PROJECT NO. PR-2020-004820

# Memorandum

**Re:** Hotel Circle Ramada Apartment Conversion DRB Comment Responses (PR-2020-004820)

AS102

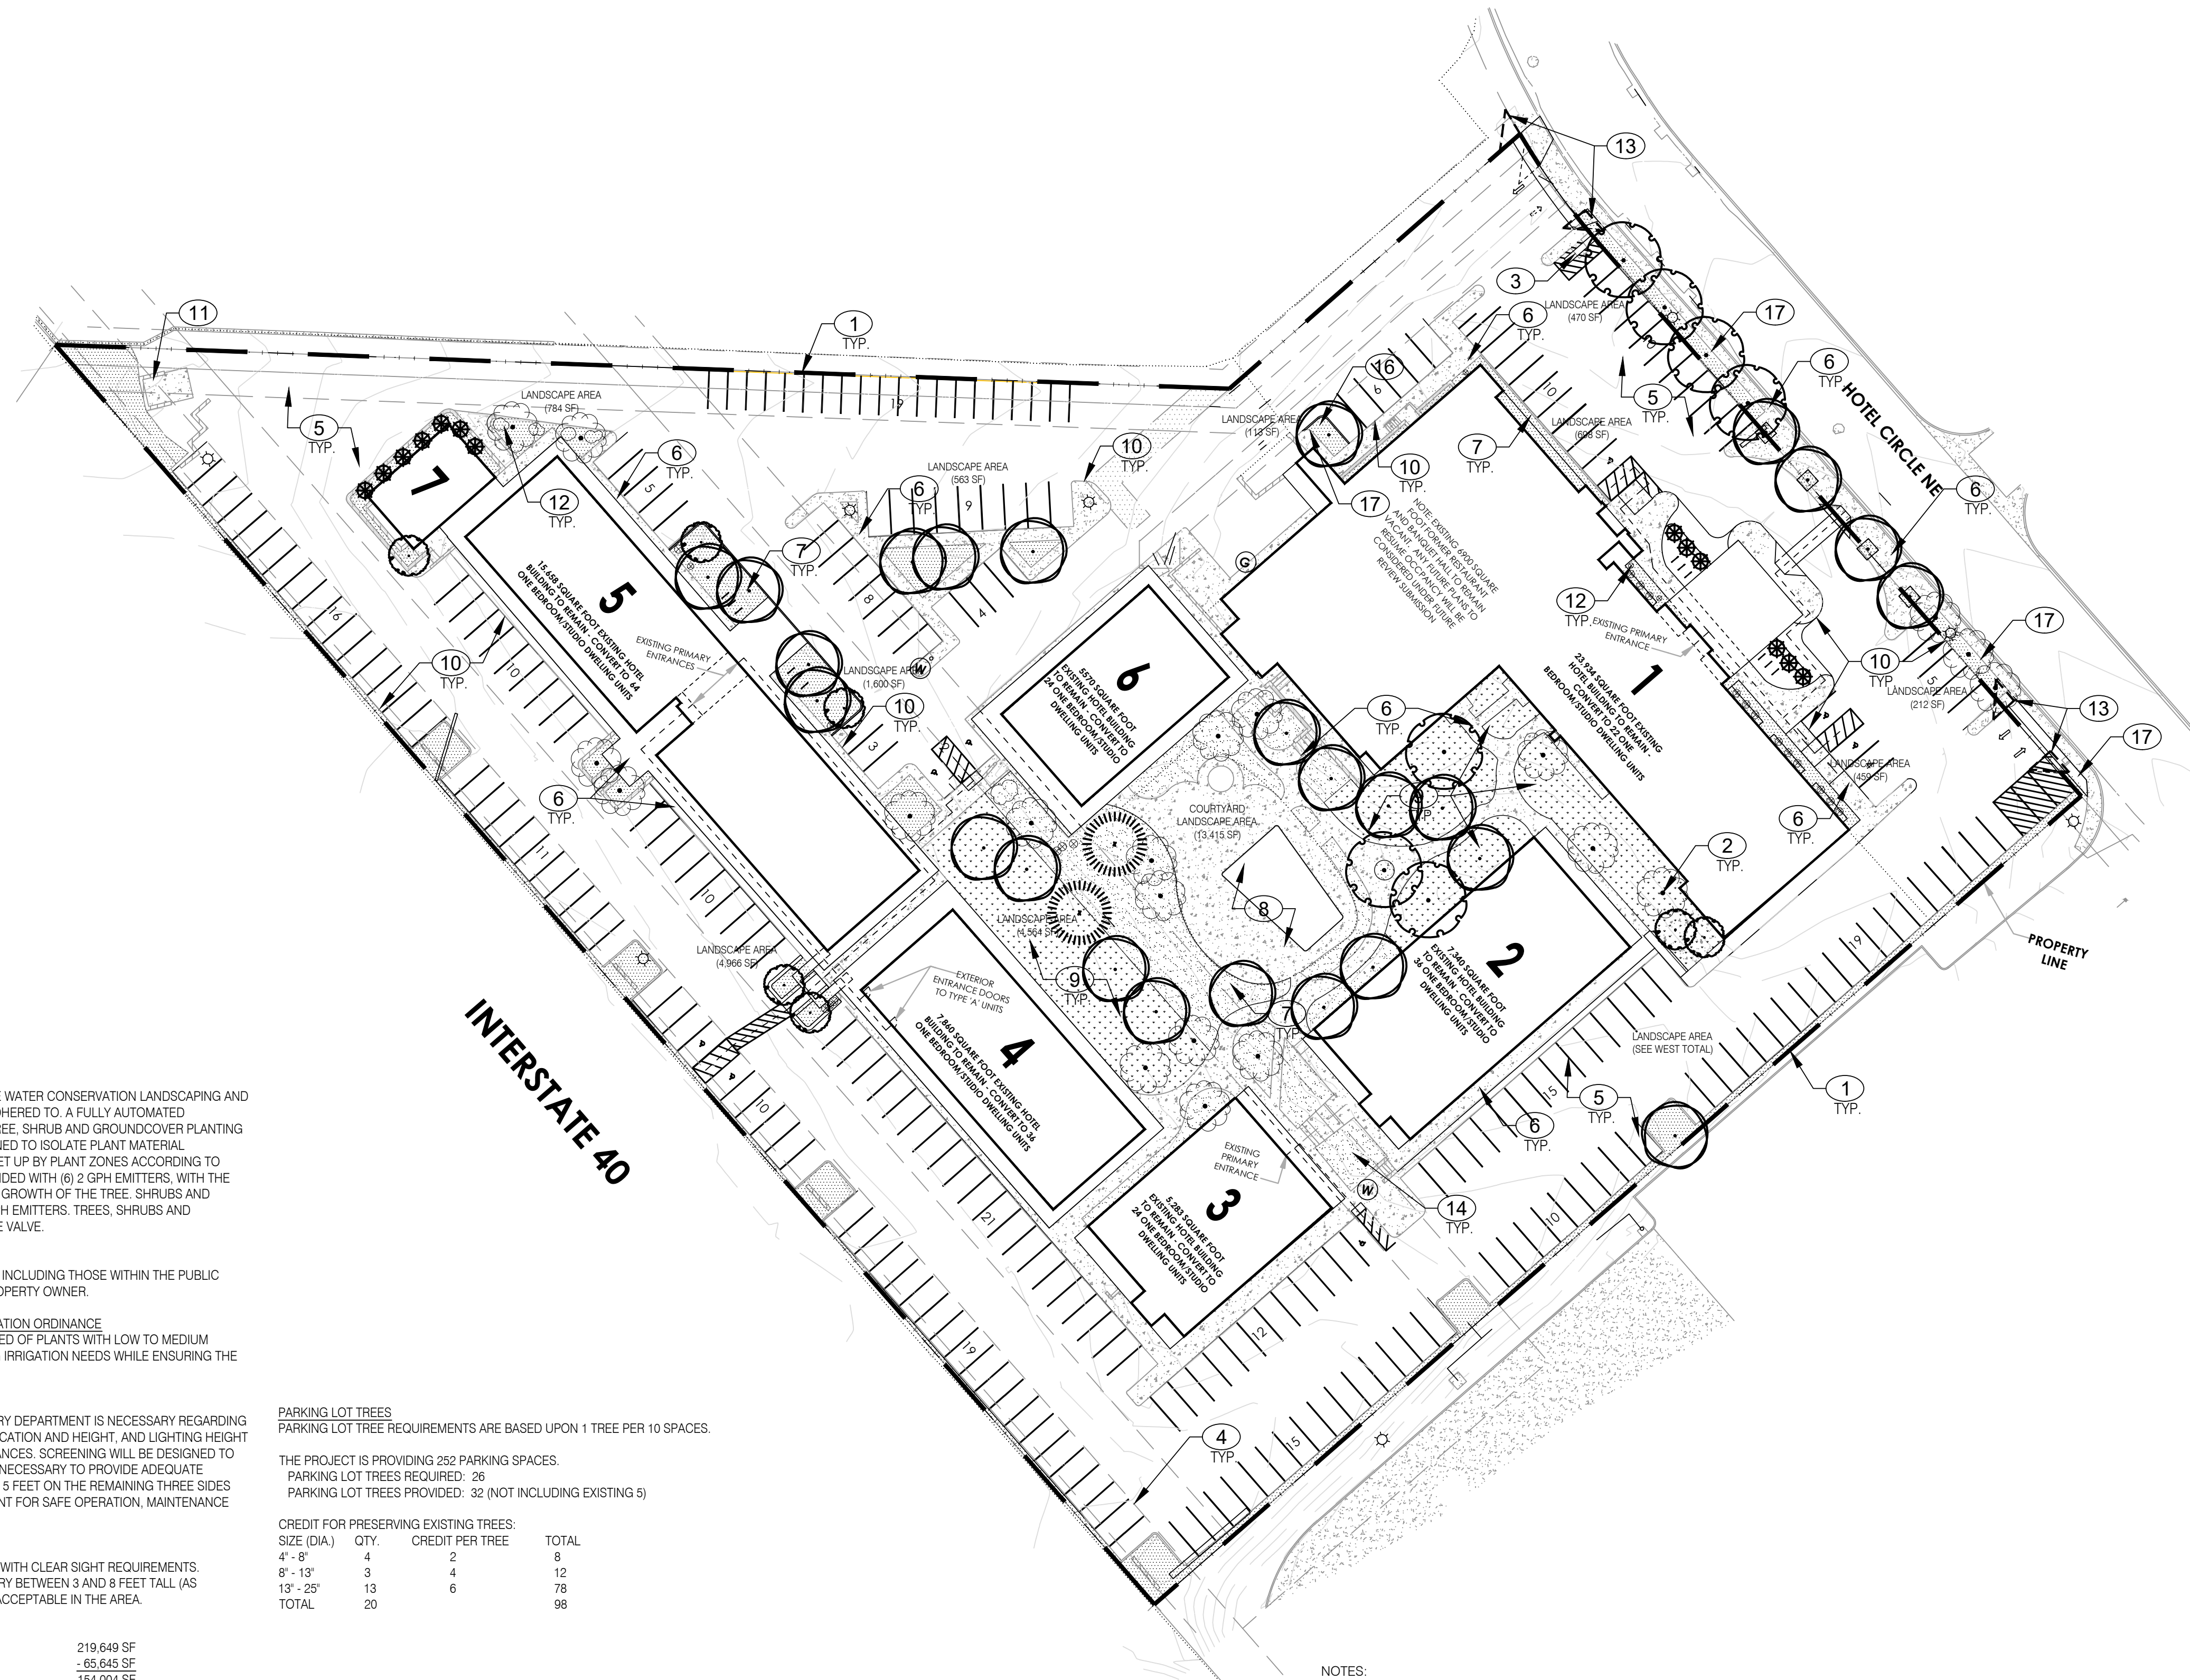
10. Provide details for the new curb, curb ramp, and sidewalk, and indicate a maximum 2% slope on the sidewalk. Curb should separate parking from sidewalks and landscape islands. Also show doorways to establish adequacy of pedestrian paths and ADA access. With notes, verify that any existing walkways establish a 6-foot ADA pathway to building and to right-of-way.

11. Provide the latest language for the handicapped sign and provide separate "Motorcycle Parking Only" sign detail.
  - a. ***Updated and new sign details have been added to Sheet AS102.***

12. The van accessible aisle shall show "No Parking" at the back of the aisle.
  - a. ***Van accessible striping details, including the required "No Parking" text is shown on Sheet AS102.***

13. Bike rack shall follow dimensioning specified in the IDO.
  - a. ***Bike racks throughout the site have been spaced according to the IDO and DPM and detailed on sheet AS102.***

- a. ***See updated details on sheets AS102 and AS103, including sidewalk, curbs & gutter, and ramps. A 6-foot ADA pathway connecting the building to the public way is being created by this plan (see Keynote #30).***
